Planning Application Ref: R/255/21/T

Location: Old Orchard House, 47 The Street, Rustington, BN16 3NU

Description of works: Various works to various trees

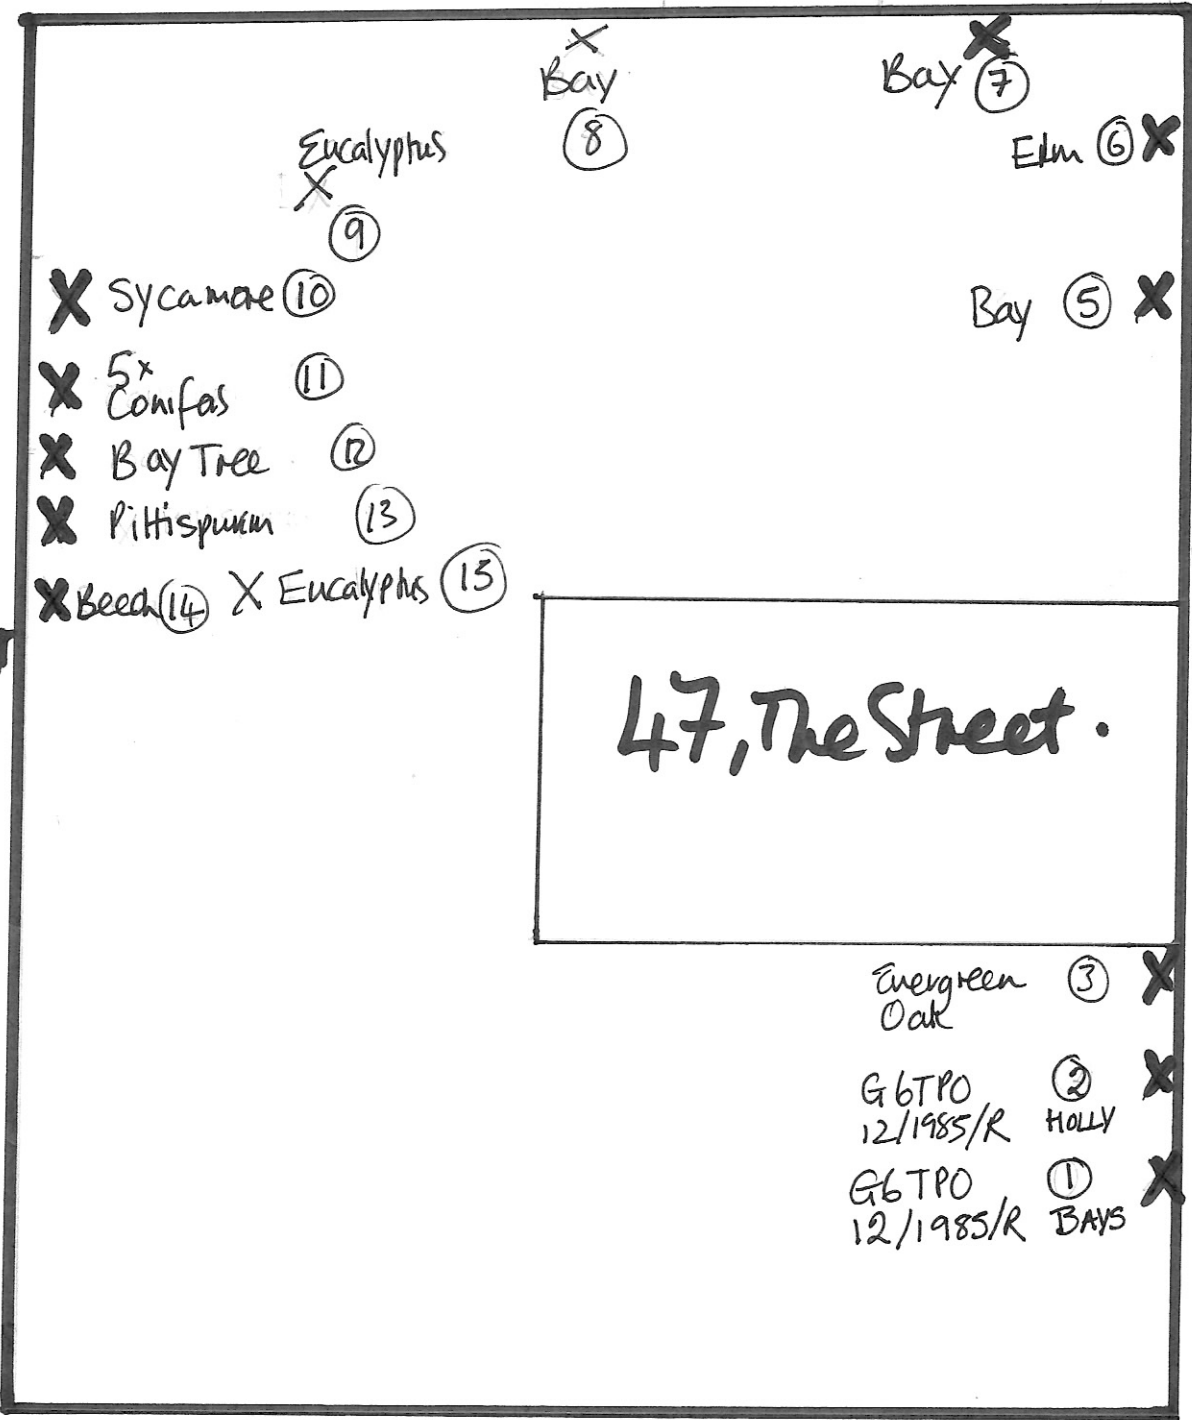
- T1 & T2 - This application proposes pruning works to a cohesive group of evergreen trees along the front boundary of the property and East of the dwelling. The group is assumed to be G6 from the schedule associated with the Order (TPO/R/2/85). It is dominated by multiple bay laurel stems, arising from what appear to be much older stumps and so this is an established feature despite the relatively young age of current growth. The holly is not obvious from roadside.
- The work now proposed is similar to that which has been undertaken before (2019) and approved by the local planning authority.
- T3 – T15 incl. - I am satisfied that the proposed works; if undertaken to a high standard and at the right time, will not result in character of the surrounding area being diminished.

- T1 & T2 - The proposal to reduce the overall height and spread of the tree group with a view to restricting growth is justified and consistent with previous works approved by the Local Planning Authority. If undertaken to a good standard and at the right time; then it is unlikely to have an adverse effect on their long-term vitality and visual amenity.
- T3 – T15 incl. - I raise No Objection to the works that have been applied for and see no reason to make a Tree Preservation Order in this instance.

- Where whole branches are to be removed and final cuts made close to the trunk or branch union they are to be made as shown in Figure 2 of BS3998:2010
- Where branches are to be shortened back the final cuts are to be made at the correct angle shown in BS3998:2010 and adjacent to a live bud or lateral.
